FOREST LAKES FILING NO. 6

SURVEY RESPONSE TO NOVEMBER 25, 2020 COMMENTS

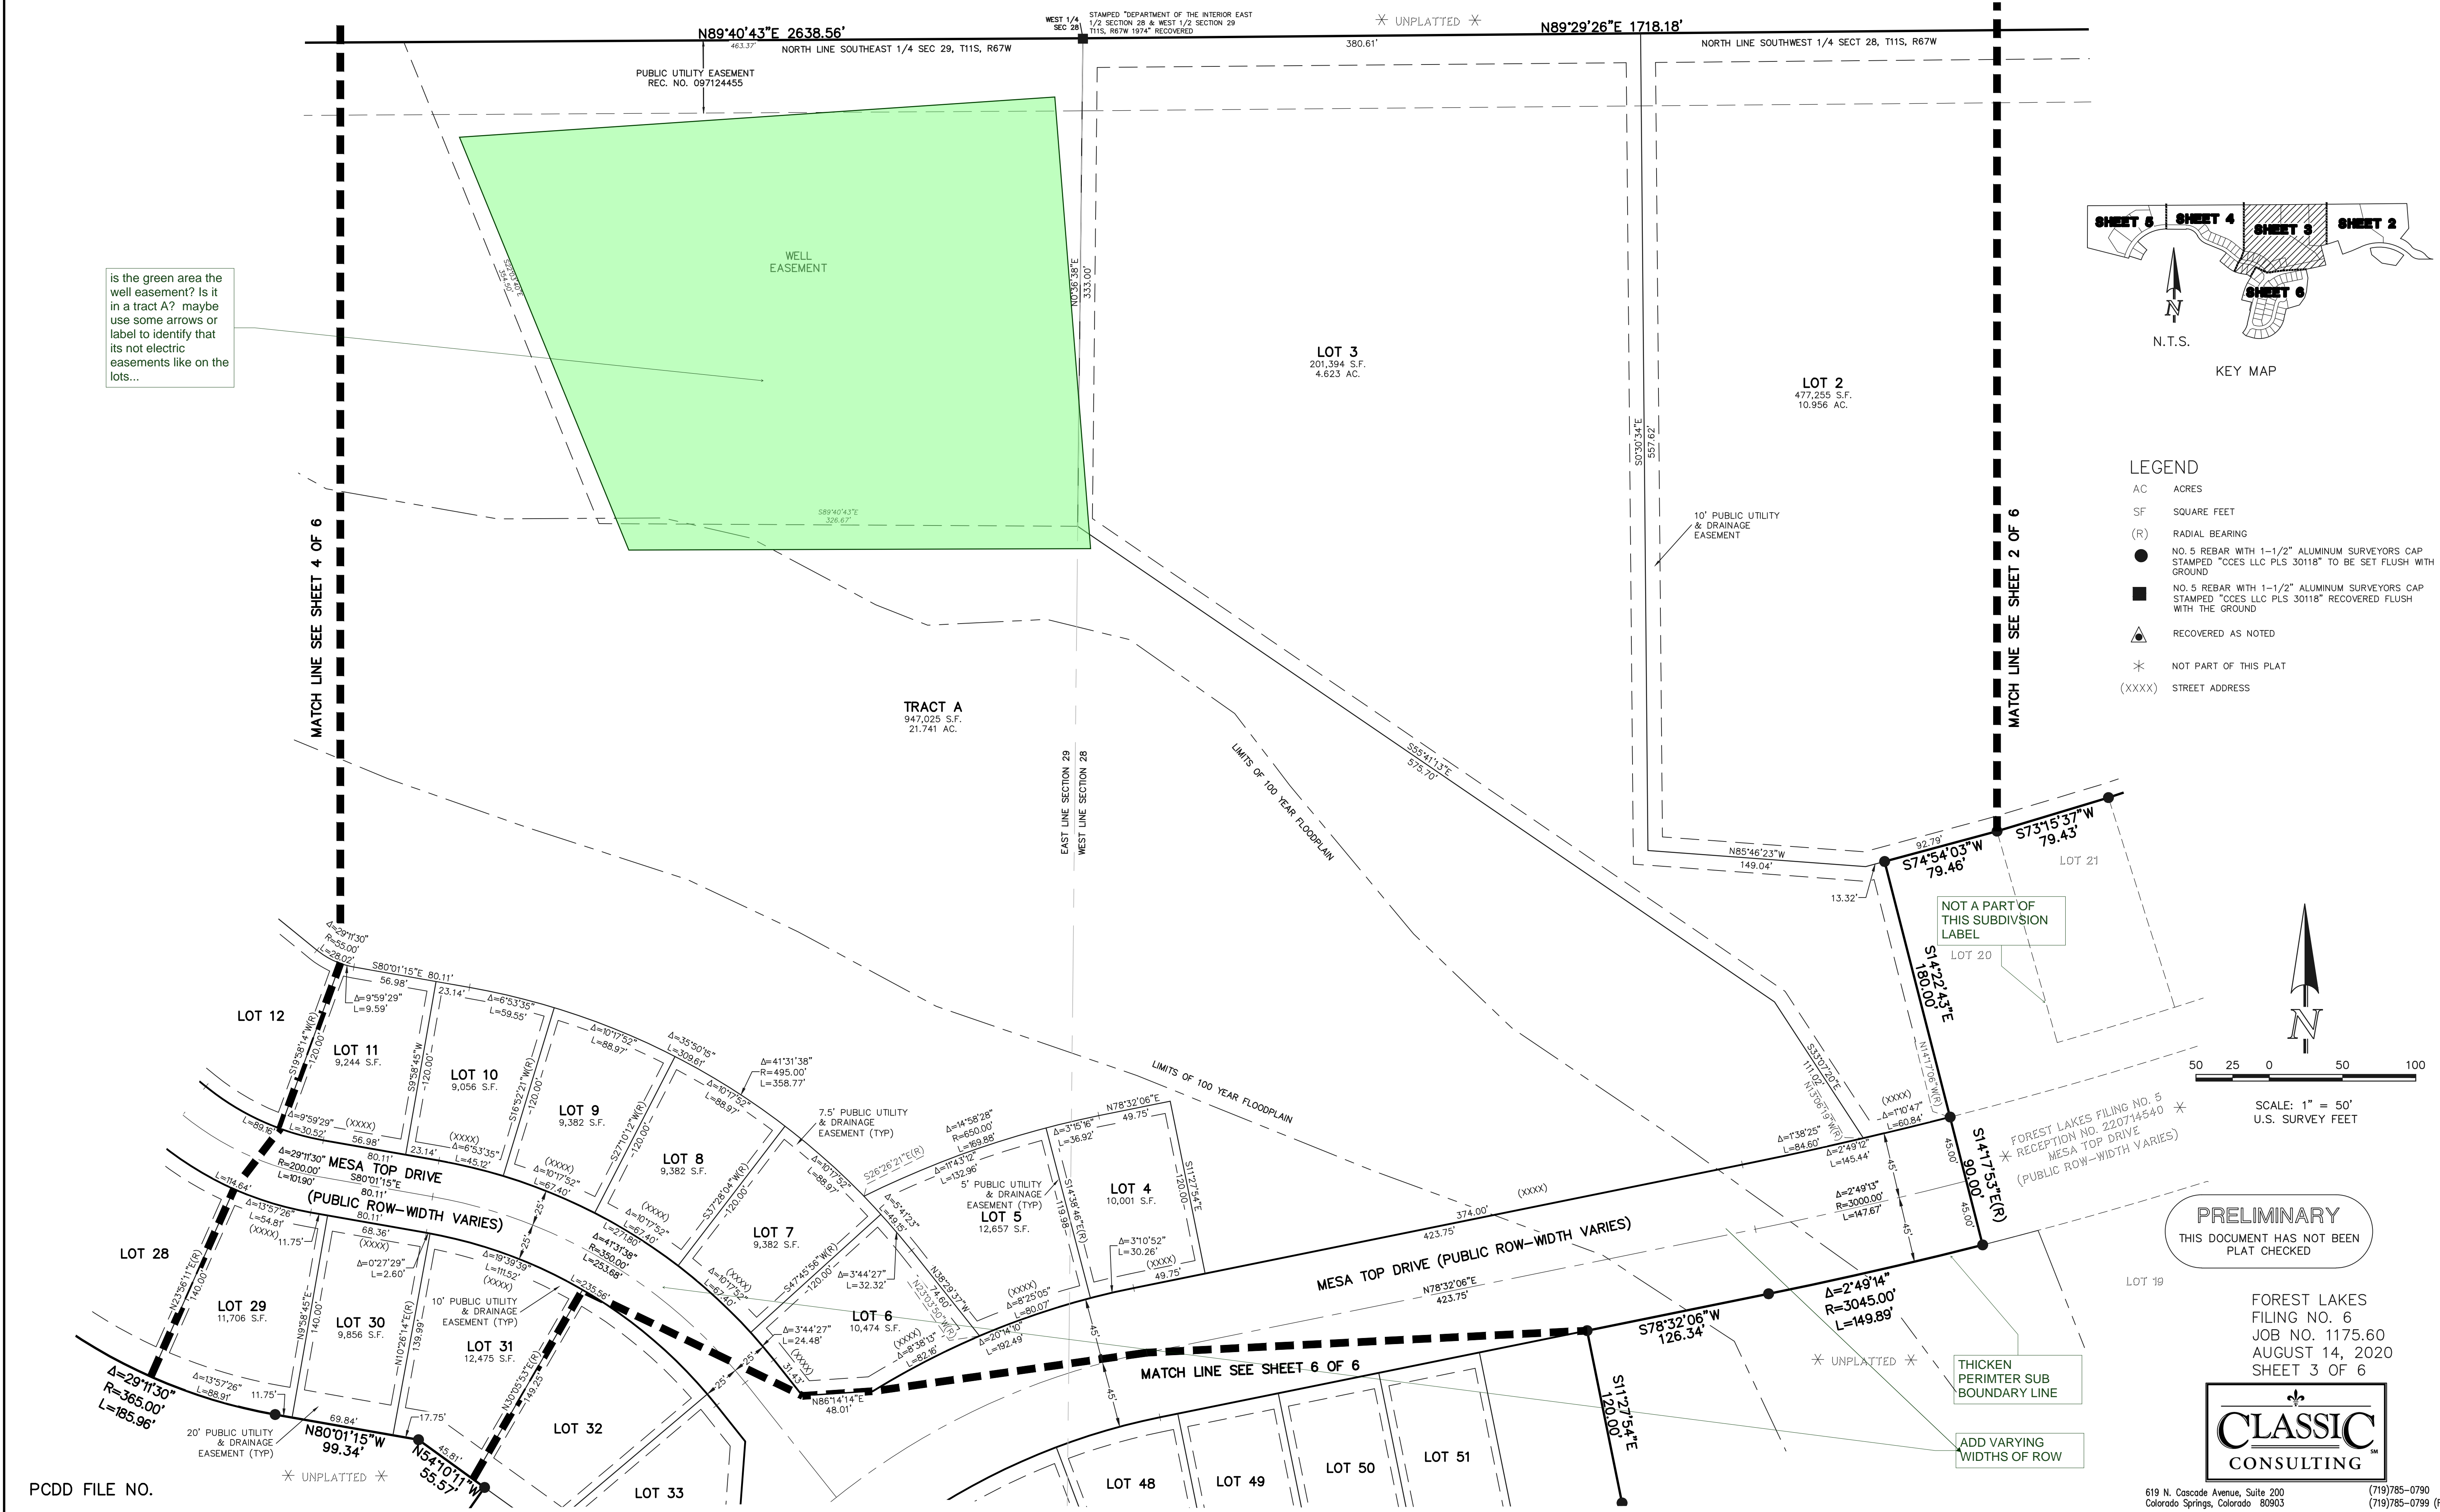
5. THE RECORDING INFORMATION OF THE WELL EASEMENT HAS BEEN ADDED.
6. A LOOPING TRAIL IS PLANNED BUT AN EASEMENT IS NOT NECESSARY IF IT IS TO MAINTAINED BY THE DISTRICT AS THE LAND OWNER.

FOREST LAKES FILING NO. 6  
 JOB NO. 1175.60  
 AUGUST 14, 2020  
 SHEET 4 OF 6

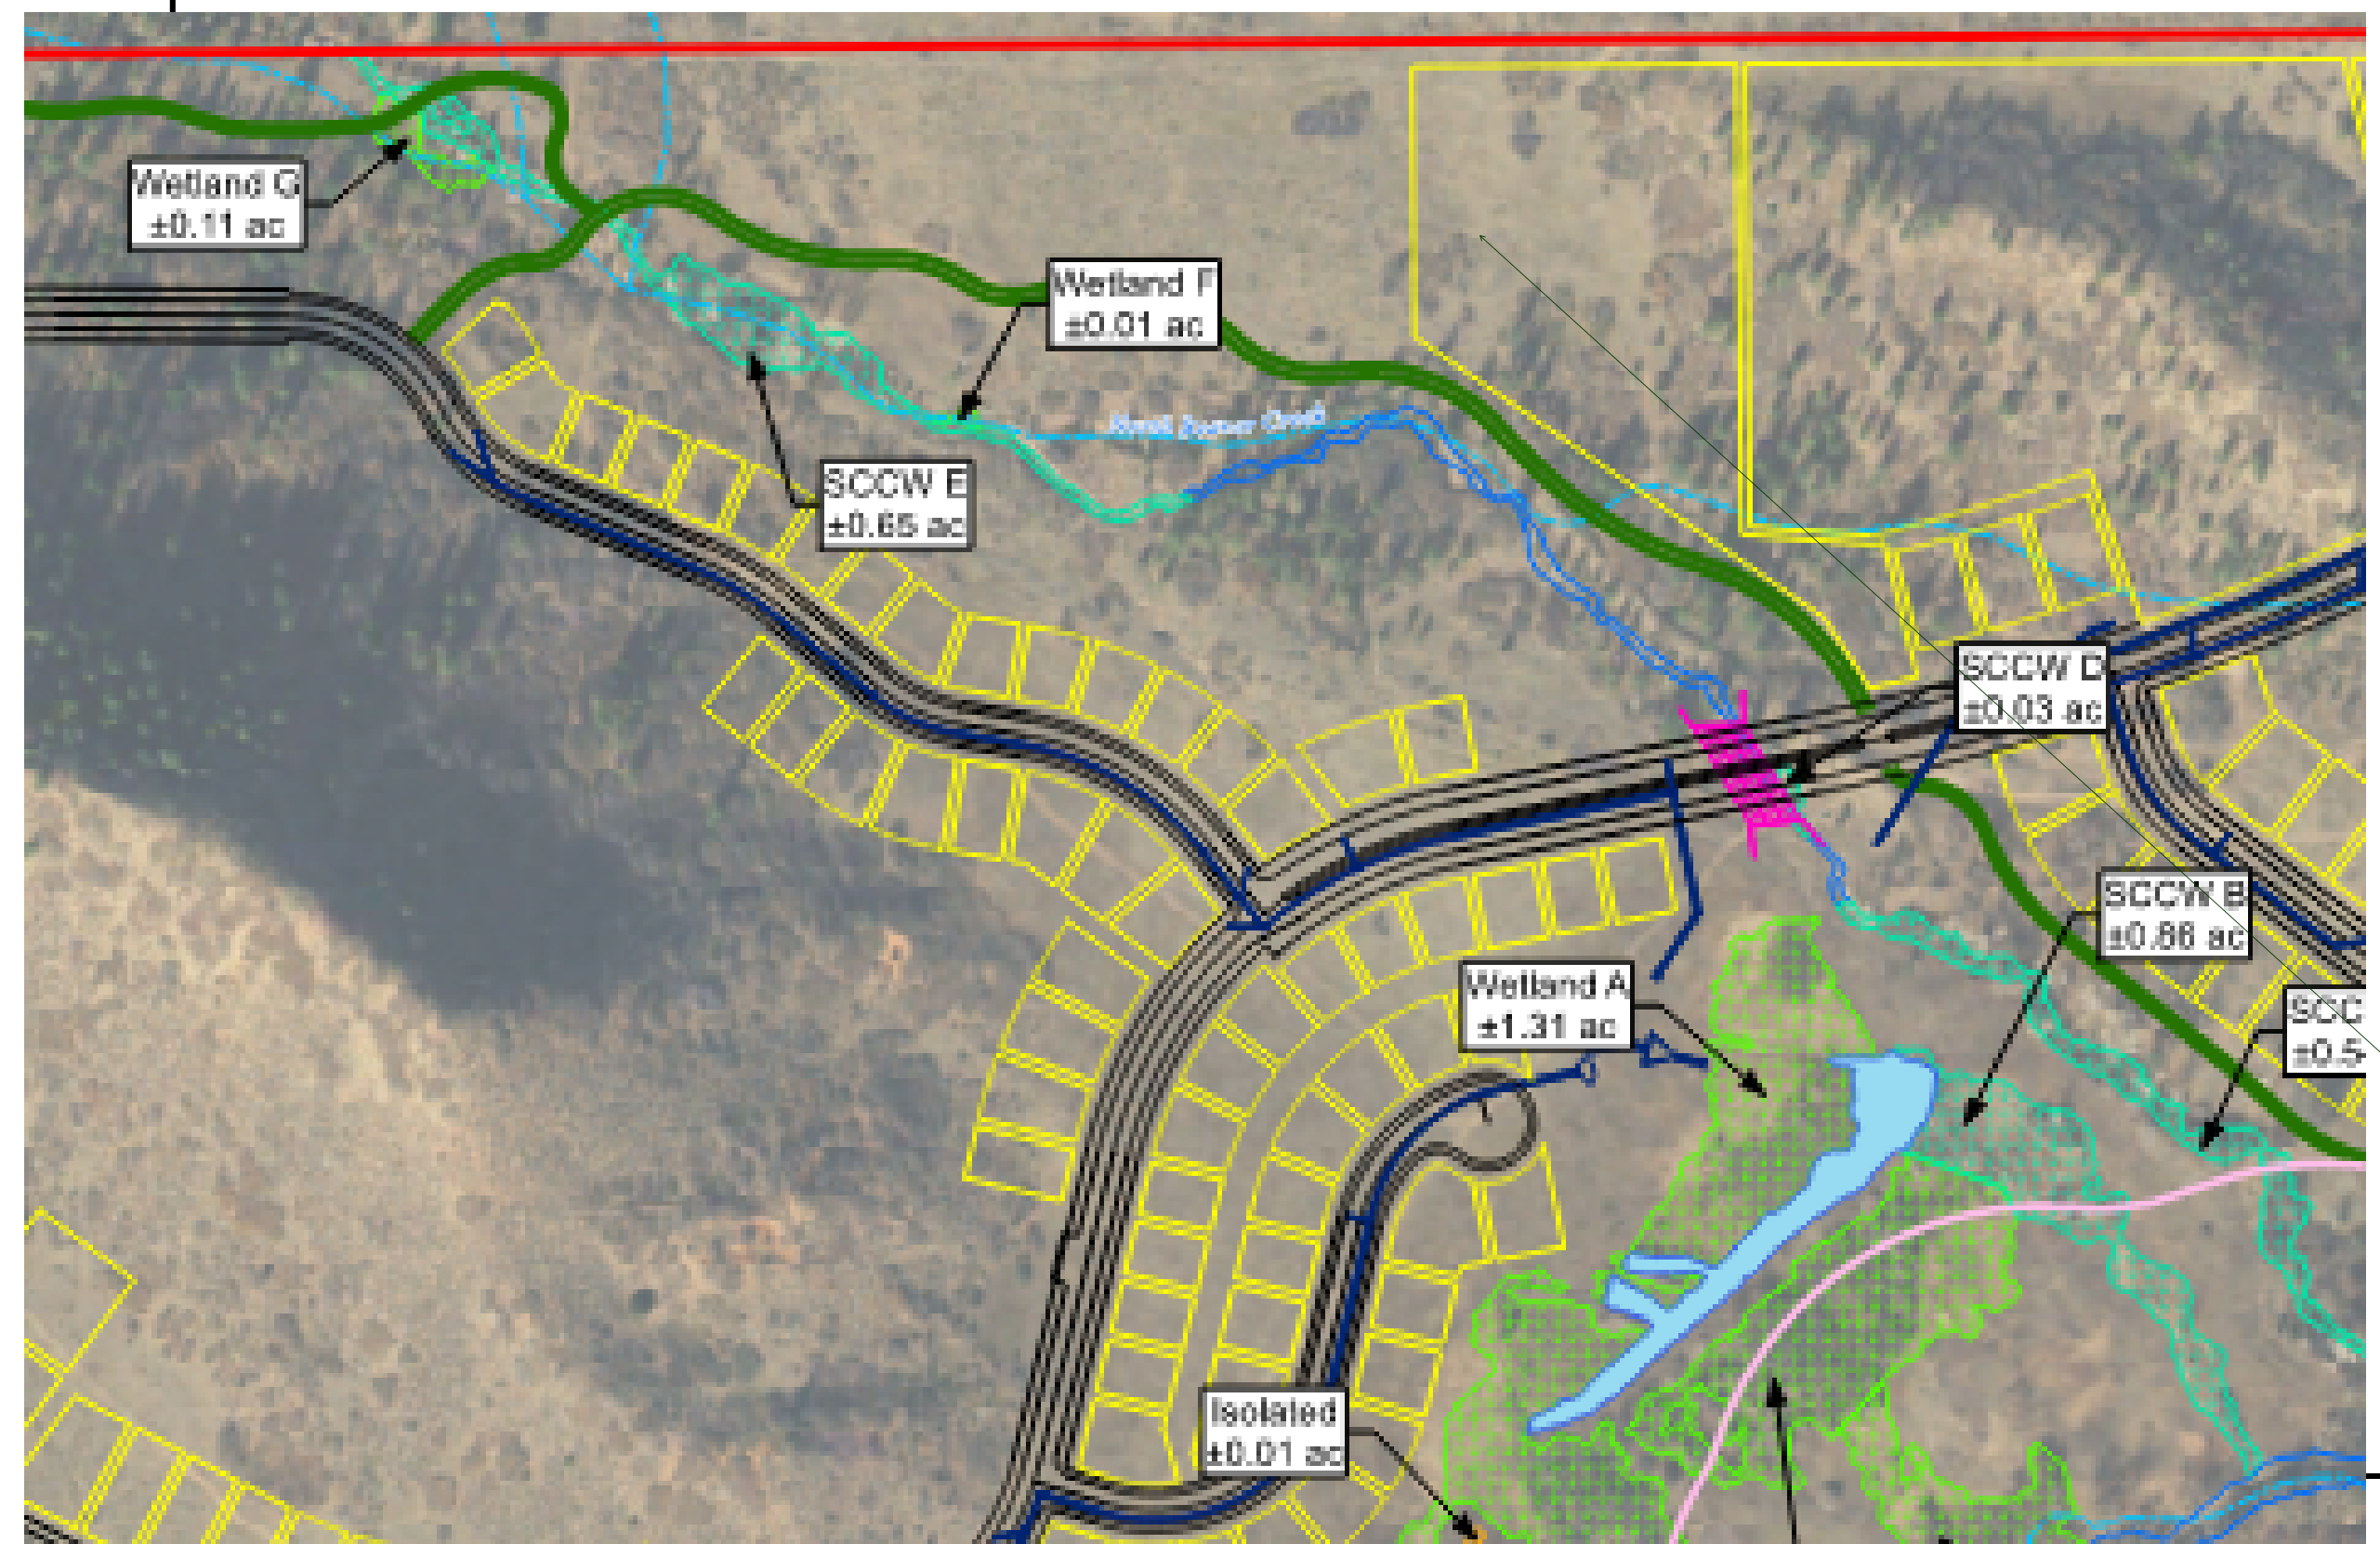
20. TRAILS ARE NOT AN ITEM TO BE SHOWN ON THE PLAT AS THEY ARE ON DISTRICT PROPERTY AND WILL BE MAINTAINED BY THE DISTRICT.
21. REVISED. WETLAND/NO BUILD AREA HAS BEEN ADDED.

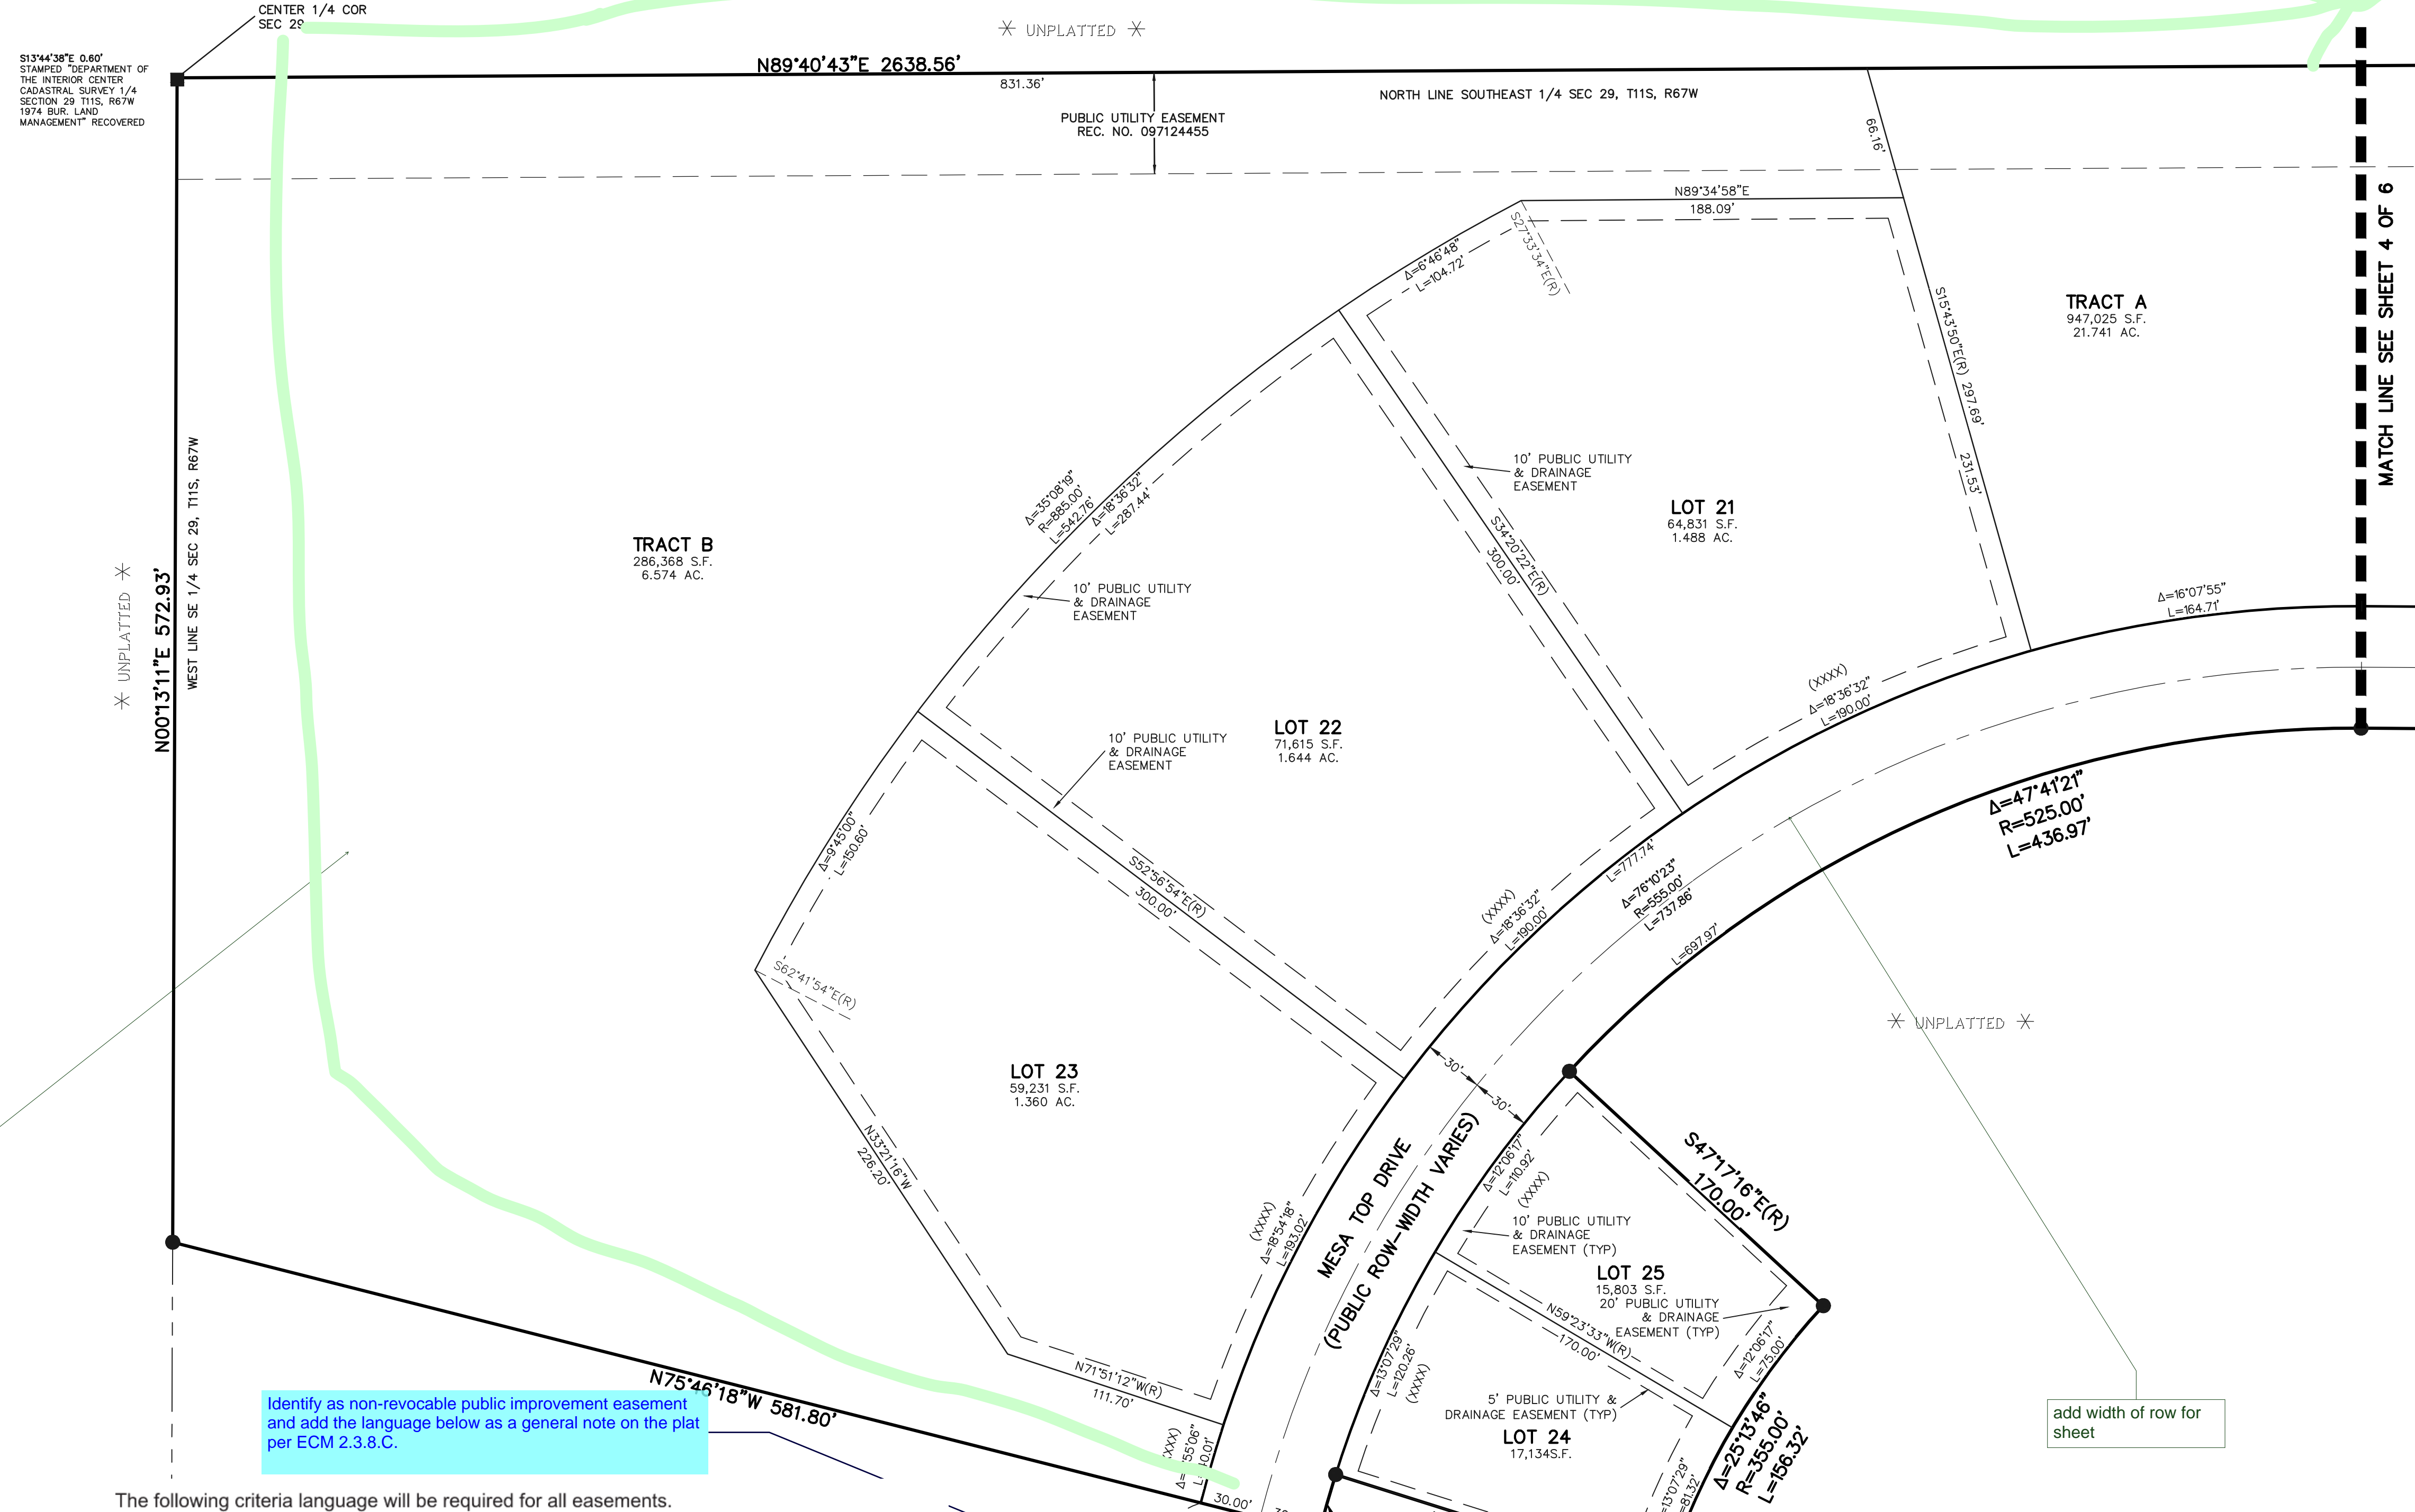
7. A LOOPING TRAIL IS PLANNED BUT AN EASEMENT IS NOT NECESSARY IF IT IS TO MAINTAINED BY THE DISTRICT AS THE LAND OWNER. OTHER TRAILS/EASEMENTS OUTSIDE THE BOUNDARY OF THIS PLAT ARE NOT PART OF THIS PLAT.
